Please could you upload the e-mail below to the application folder BE/70/20/DOC as a consultation response from ADC Drainage Engineer?

Condition 6- surface water drainage design

TYPICAL FOUL MANHOLE DETAIL - TYPE 2  
MAXIMUM DEPTH FROM COVER LEVEL TO SOFFIT OF PIPE 3.0 M

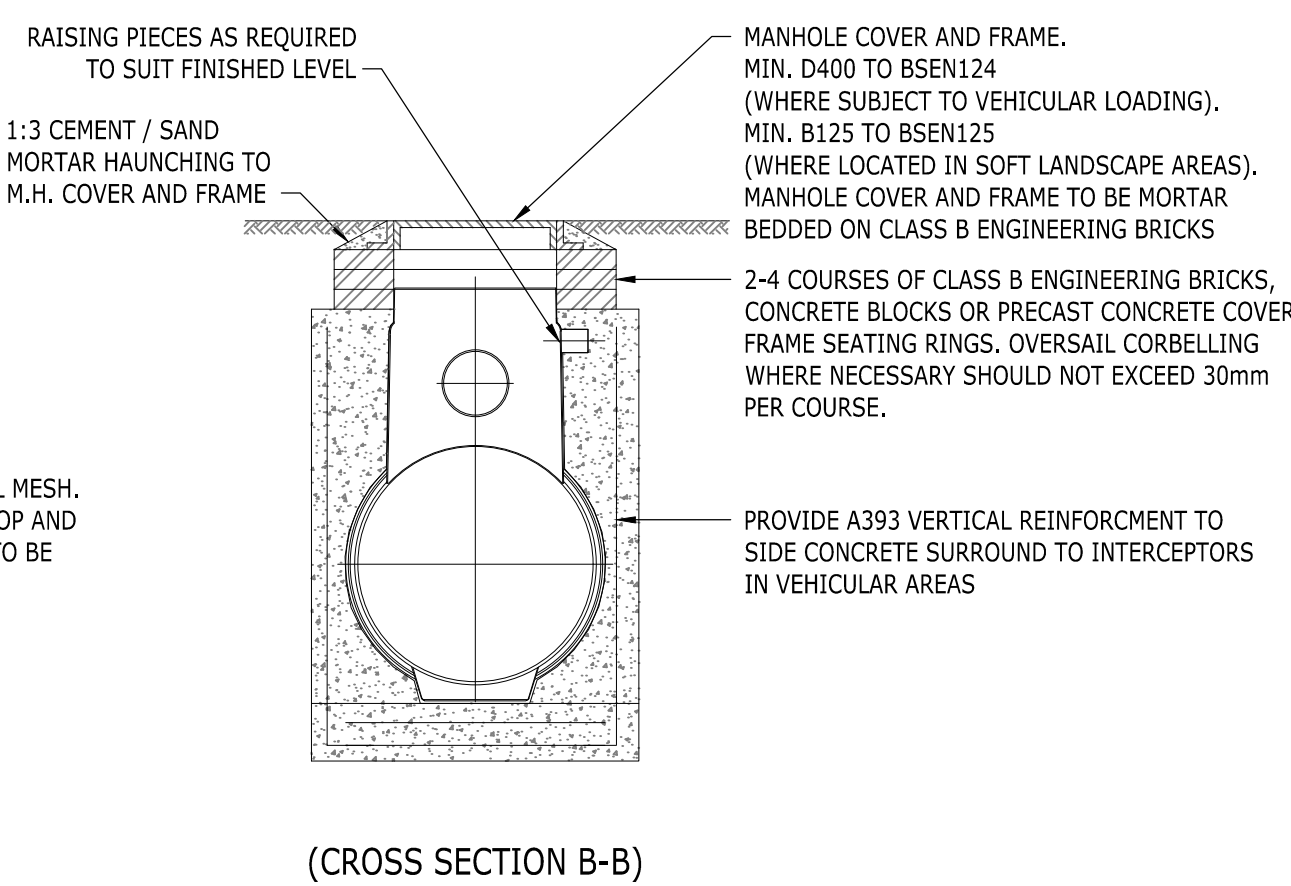
5. A construction detail drawing should be provided for each of the proposed flow control devices, i.e. one of the hydrobrake with overflow at MH9 and one of the orifice at MH7. These should be site specific, with orifice diameters, hydrobrake references and levels specified.

6. Please detail the requirements that the full detention separator must meet. E.g. size, standards.

Project No: 1620003993	Scale (@A1): AS SHOWN	Drawn: BW	Date: JUN.19
Drawing No: RAM-0500-01A-D-CR-20101			Rev: P04

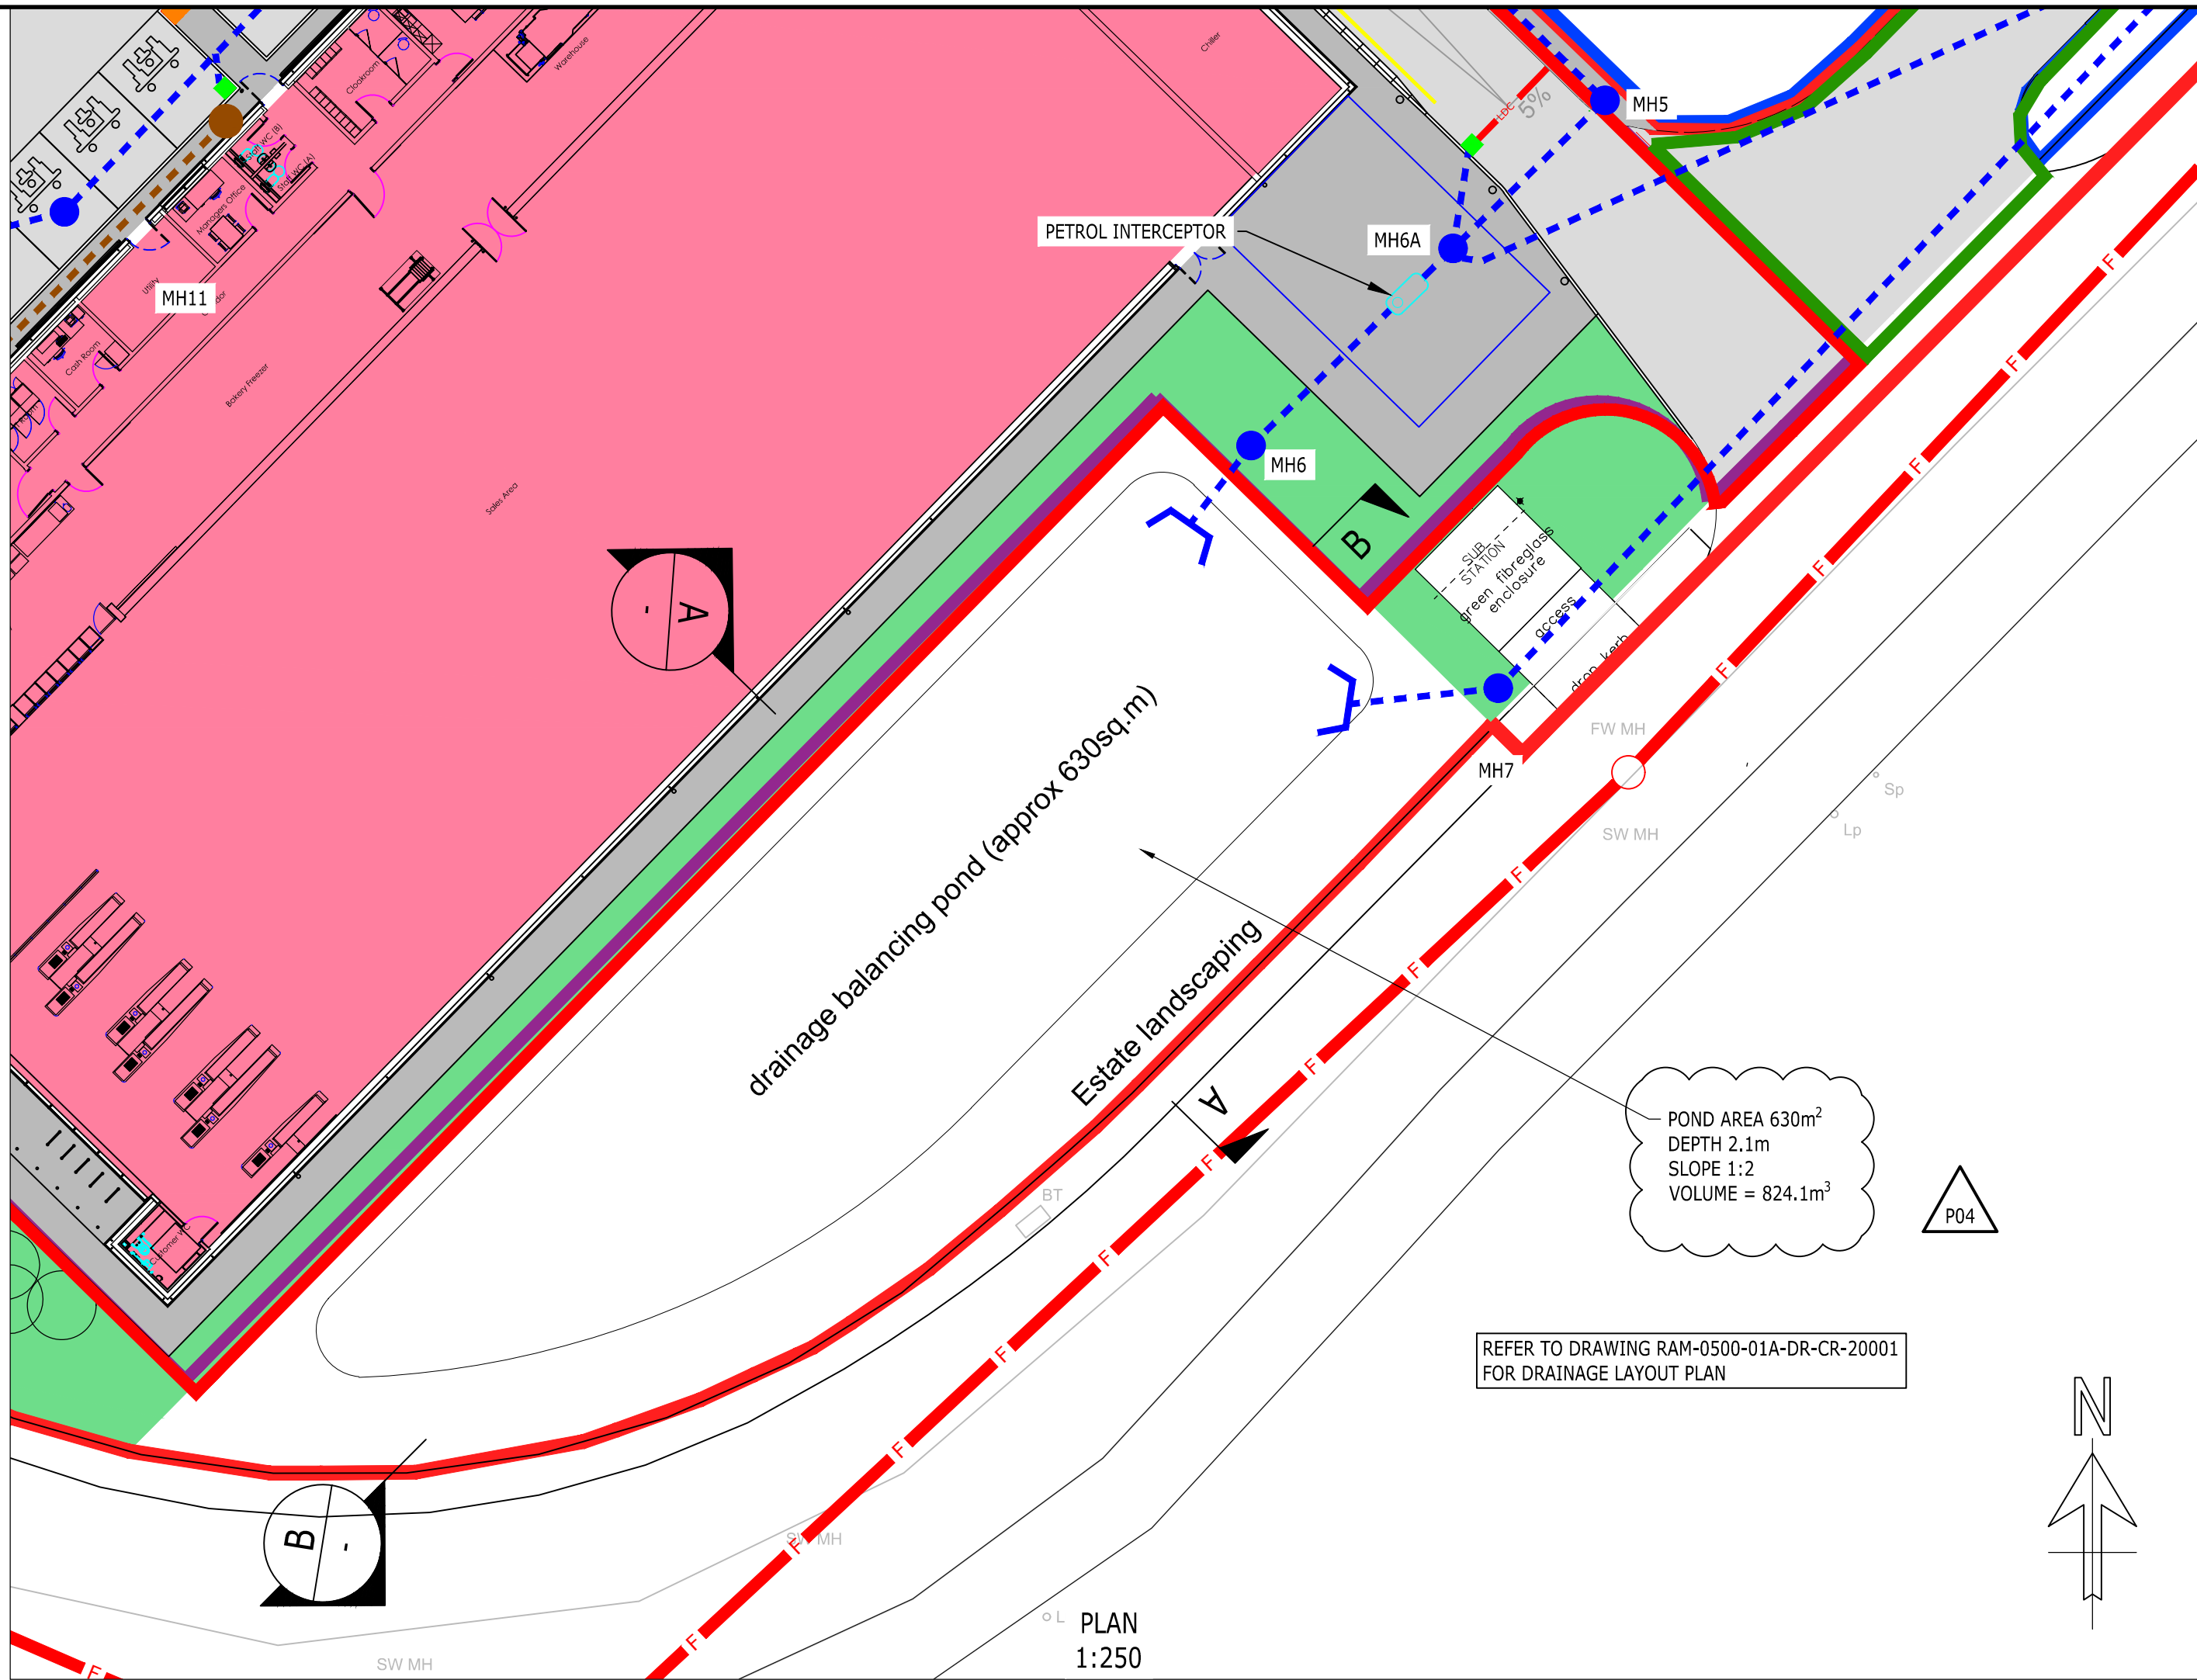
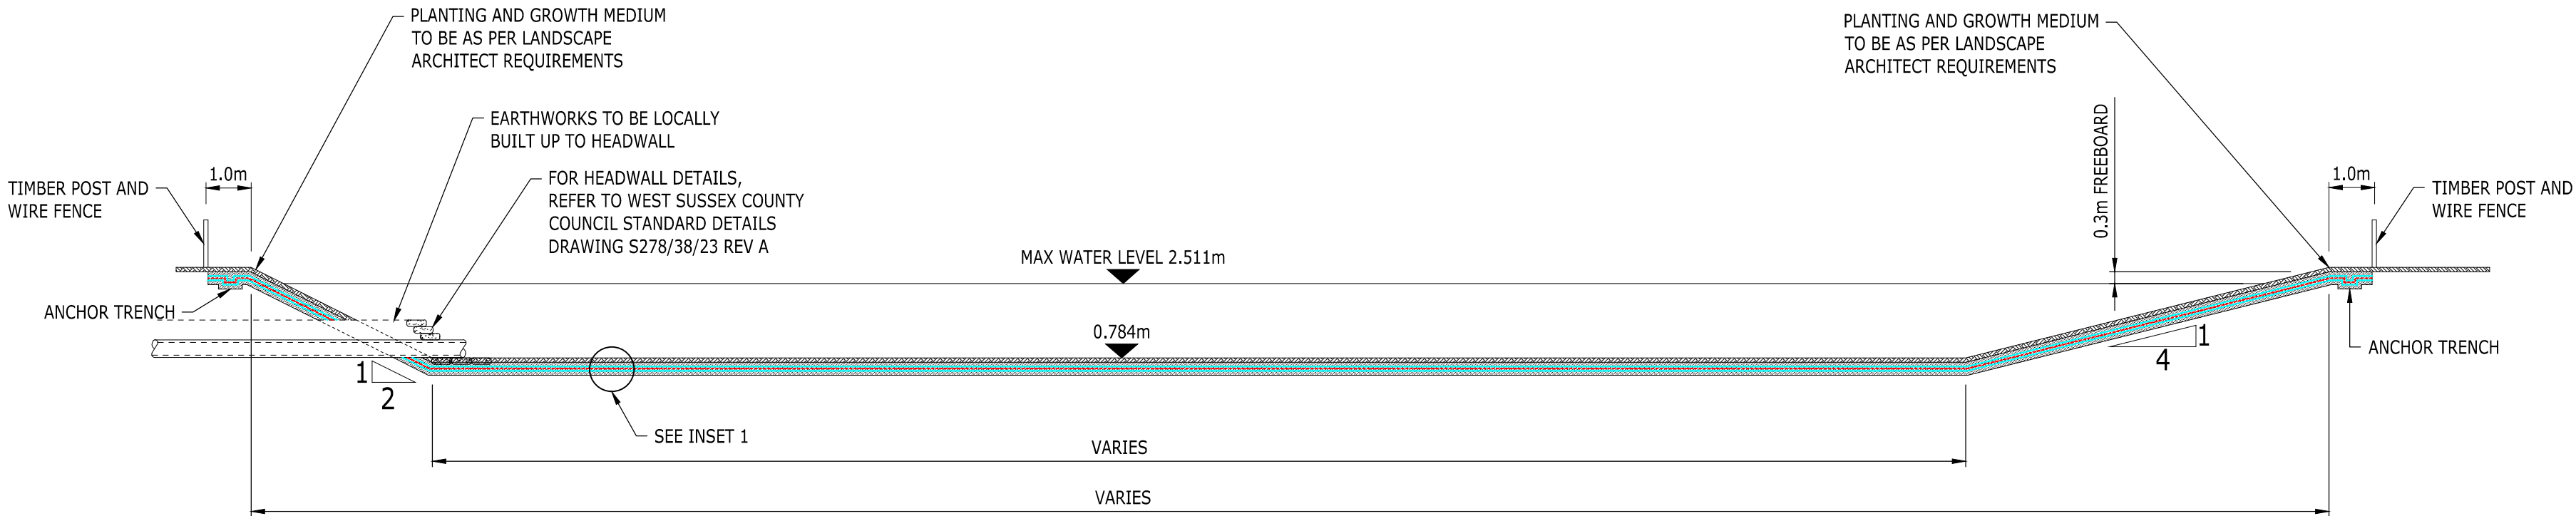
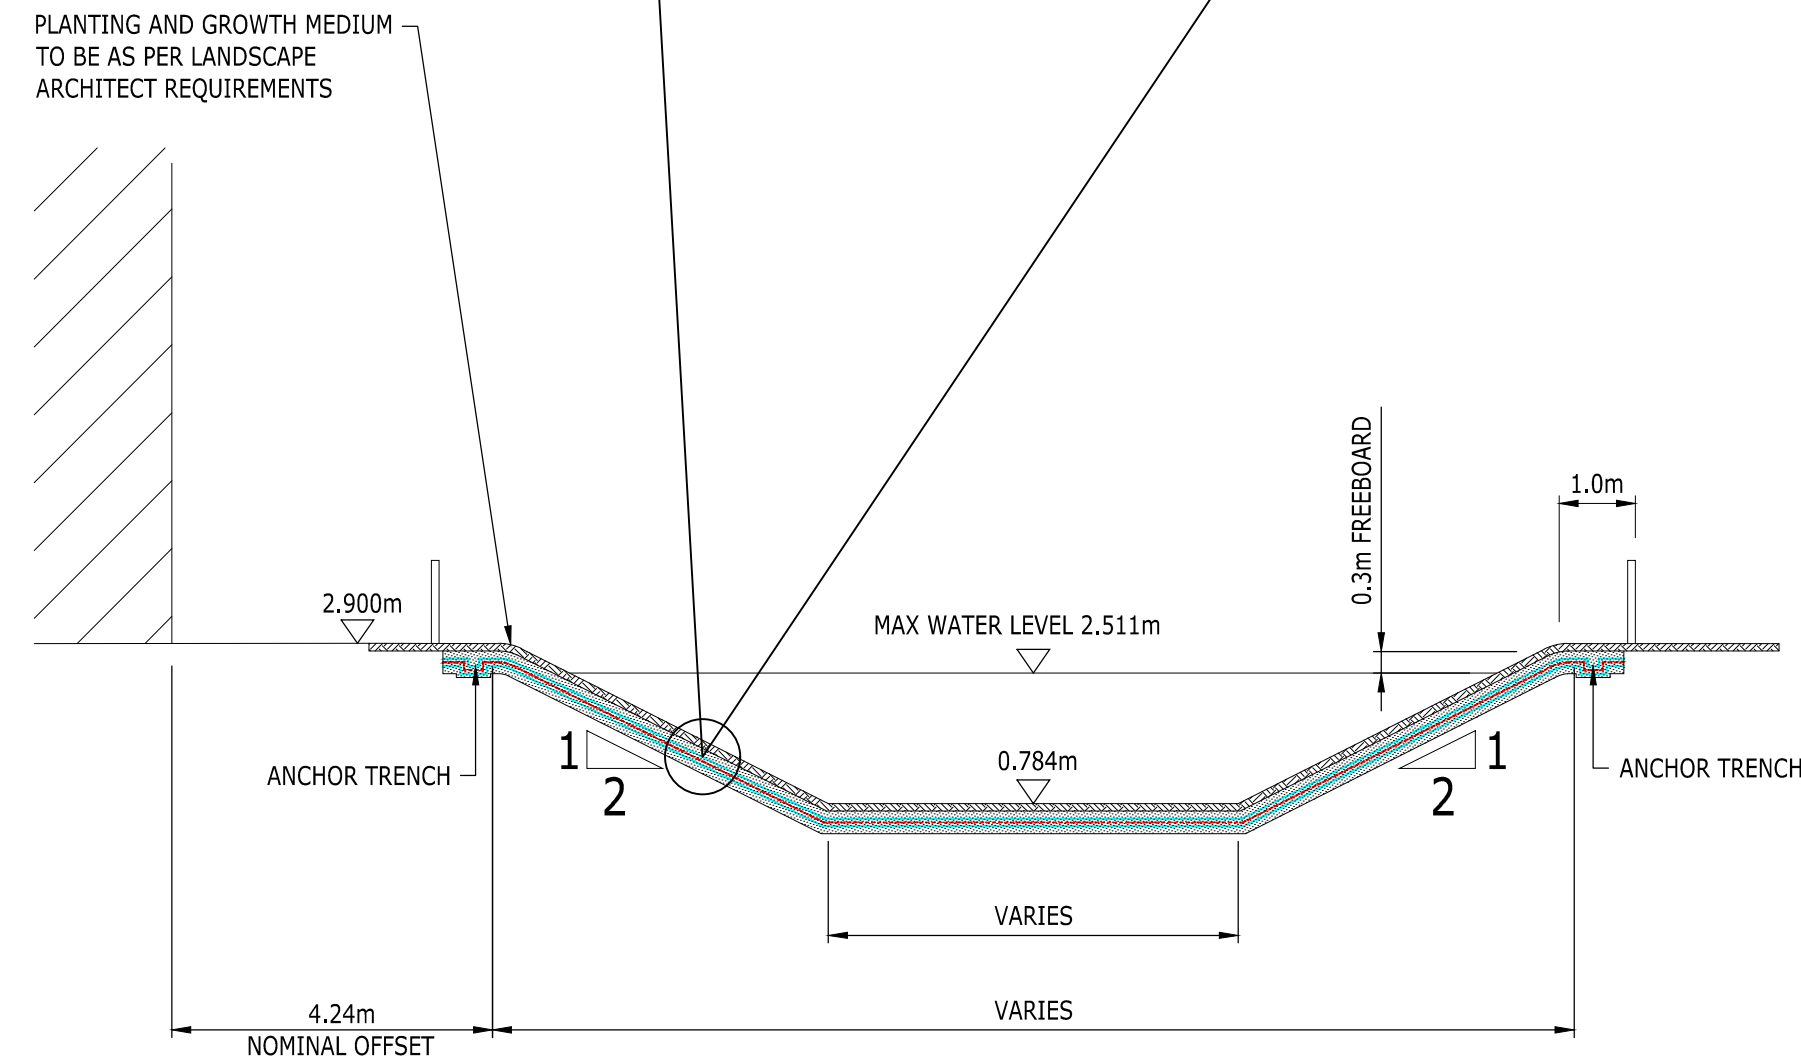
3. Modelled invert and cover levels are inconsistent to those on plan.
4. An overflow is proposed from the main flow control device at MH9. The overflow is proposed to be located above the 1 in 30 plus 30% cc level. The overflow must be located above the 1 in 100 year plus cc level.
